North Lincolnshire Council

Planning Inspectorate's Reference: EN010148

Subject: Application for an Order Granting Development Consent for the Tween Bridge Solar Farm

DEADLINE 4 SUBMISSION

Zones of Impact are subject to refinement following detailed design, the figure presents a worst-case scenario on the basis of current understanding

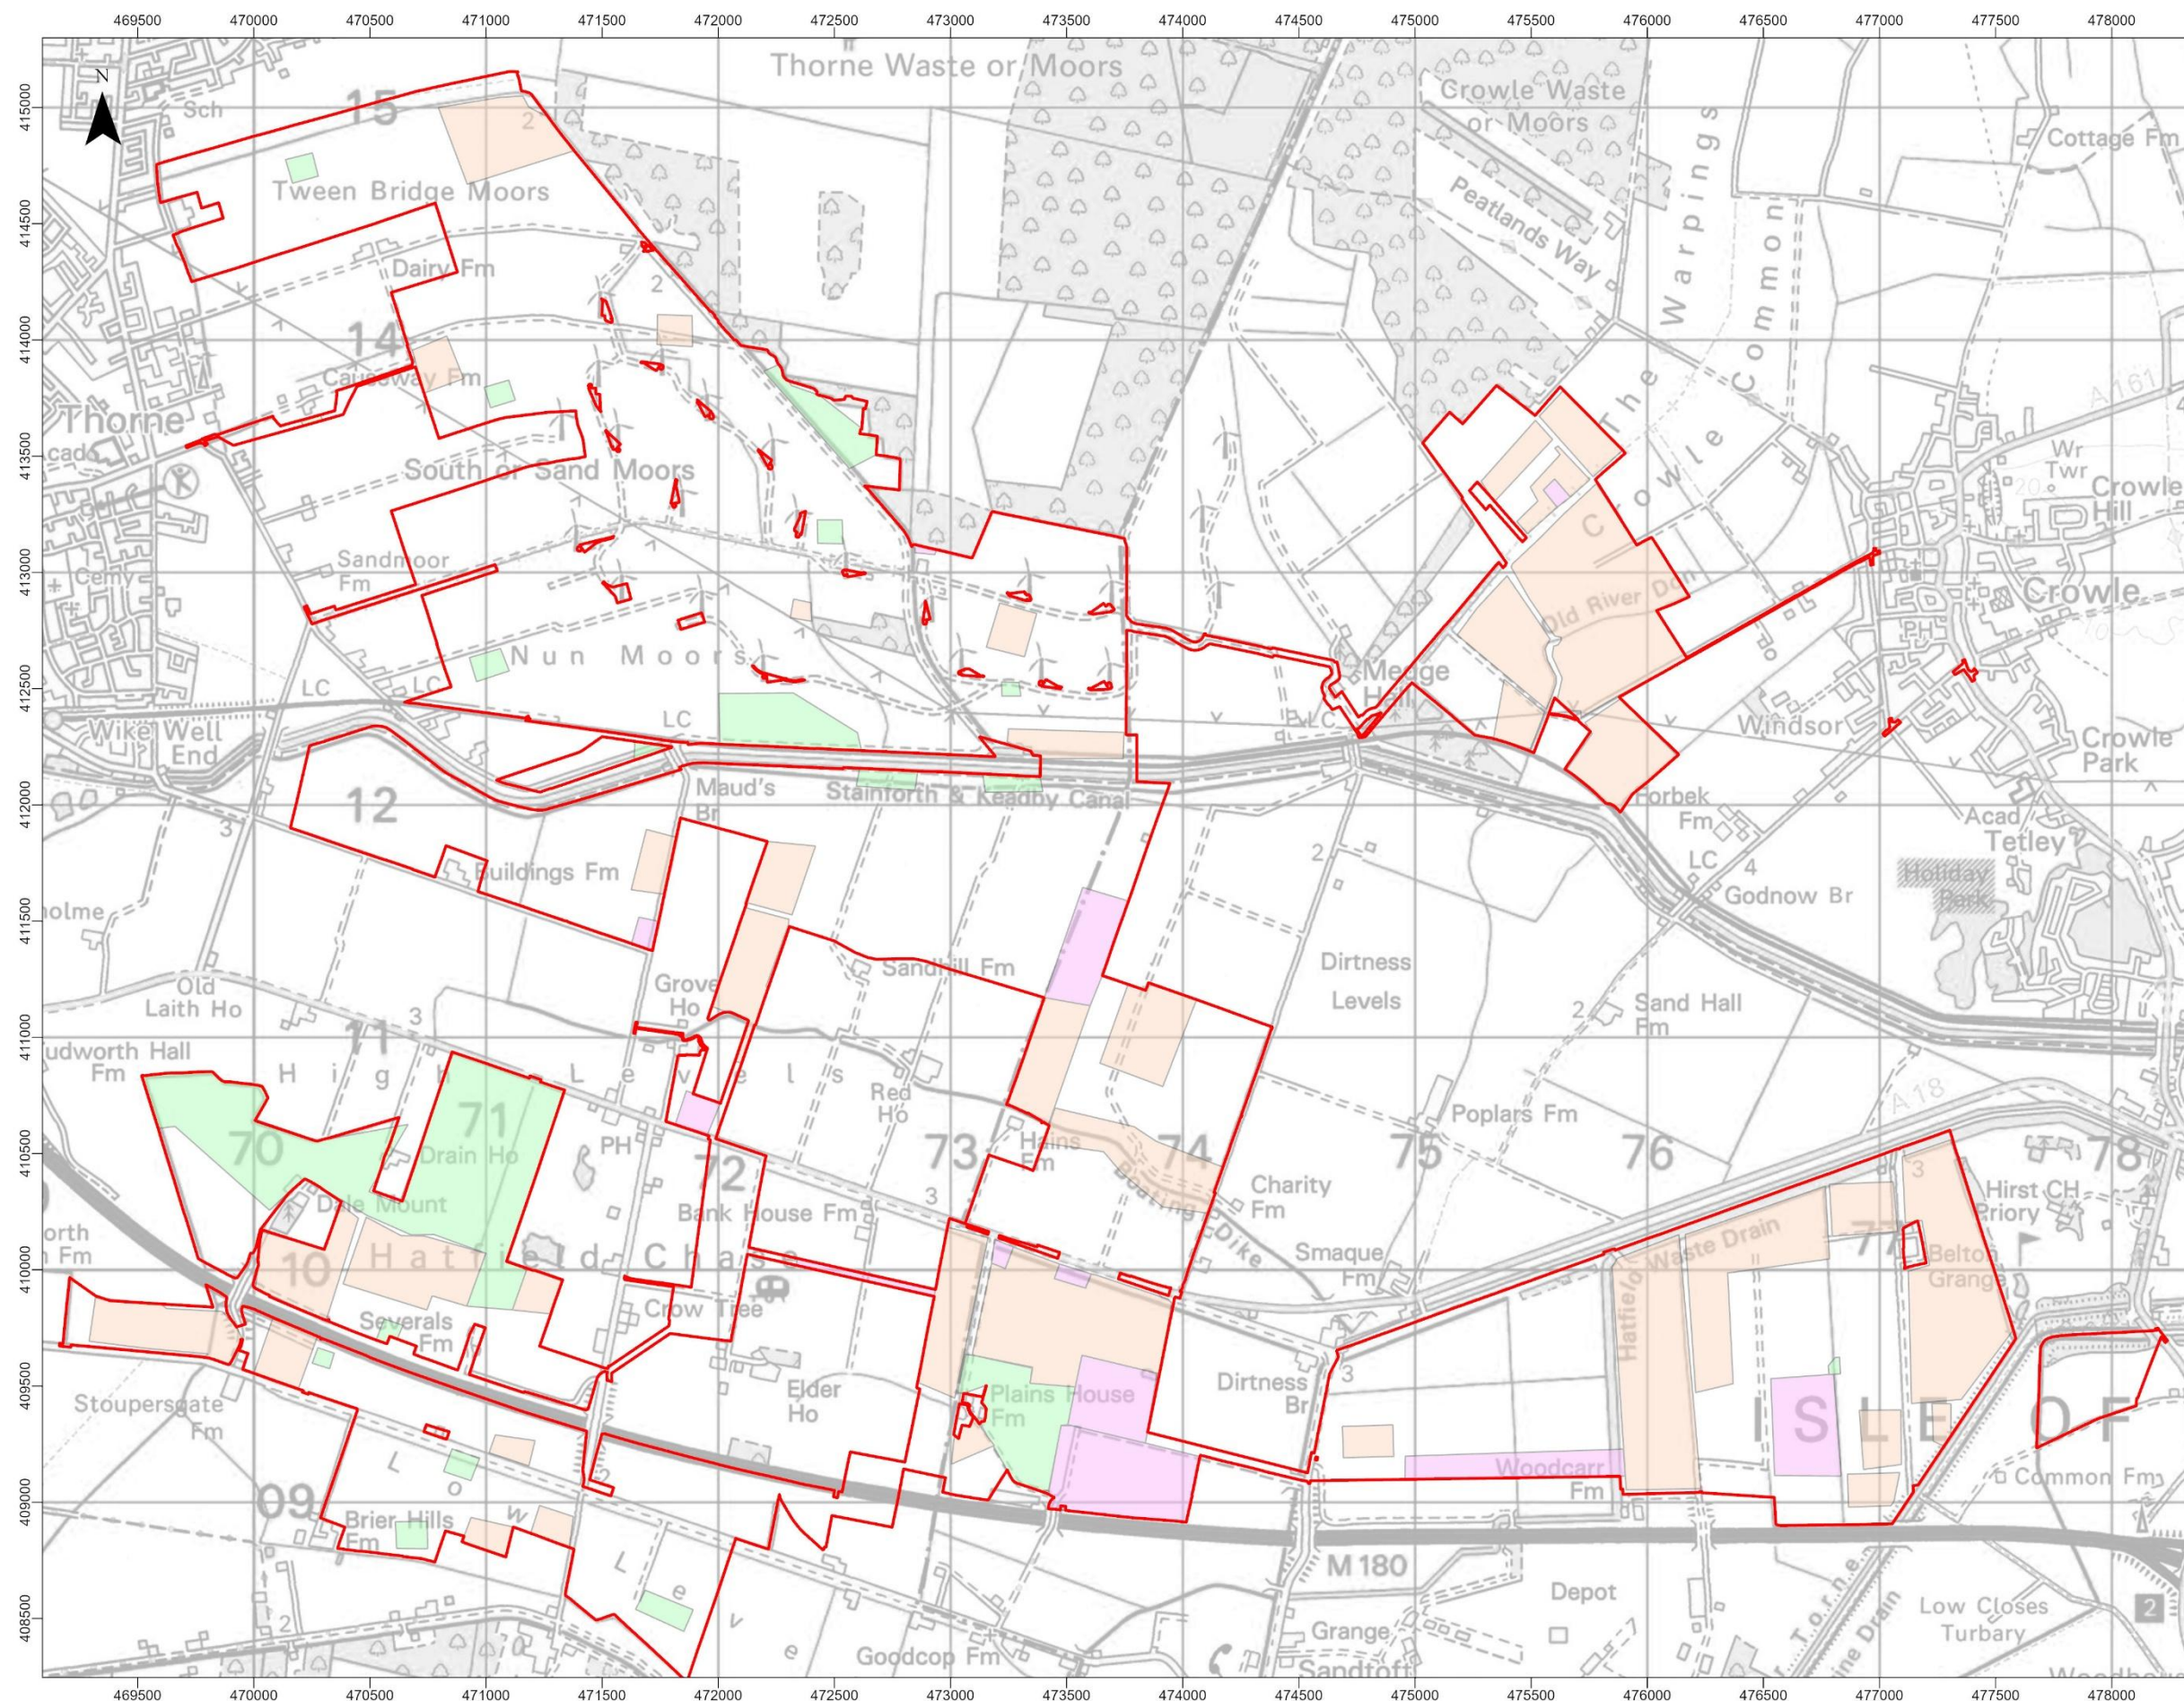
ExQ2	Question	NLC Response
		5. NLC agrees that the zones of sensitivity should be prepared on a worst-case scenario basis 6. NLC notes that CDC has agreed to provide examples of zoning plans received from other schemes as examples. 7. NLC notes that due to the complexity of finalising the revisions to the zoning plan the Applicant intends to issue it at Deadline 5, with the additional zones of sensitivity and a revised version of the oAMS using the currently available version issued at Deadline 4.
Q2.6.6	Dirtiness Pumping Station (Grade II) Paragraphs 12.28 to 12.30 of NLC's LIR [REP1-063] address the effect of the proposed development on Dirtiness pumping station. Could NLC please confirm whether it is suggesting 'less than substantial harm' would occur? Could the applicant also provide a response on this? Could the applicant and NLC update the ExA on any progress made in amending the proposed layout, as indicated at NLC LIR paragraph 12.30?	NLCs view is that the submitted layout would result in less than substantial harm, but not 'at the lower end' as suggested by the Applicant. NLC notes that, in response to the Council's comments, the Applicant has considered the feasibility of increasing the extent of mitigation proposed in relation to Dirtiness Pumping Station and proposes to alter the scheme in this area to include a strip of land that allows glimpsed views of the asset when approaching along the road to the south-west. Subject to those amendments, NLC would conclude that, subject to the SoS's conclusions in respect of the weight to be afforded to the benefits of the scheme, that those benefits would outweigh any residual effects on the setting of the pumping station.
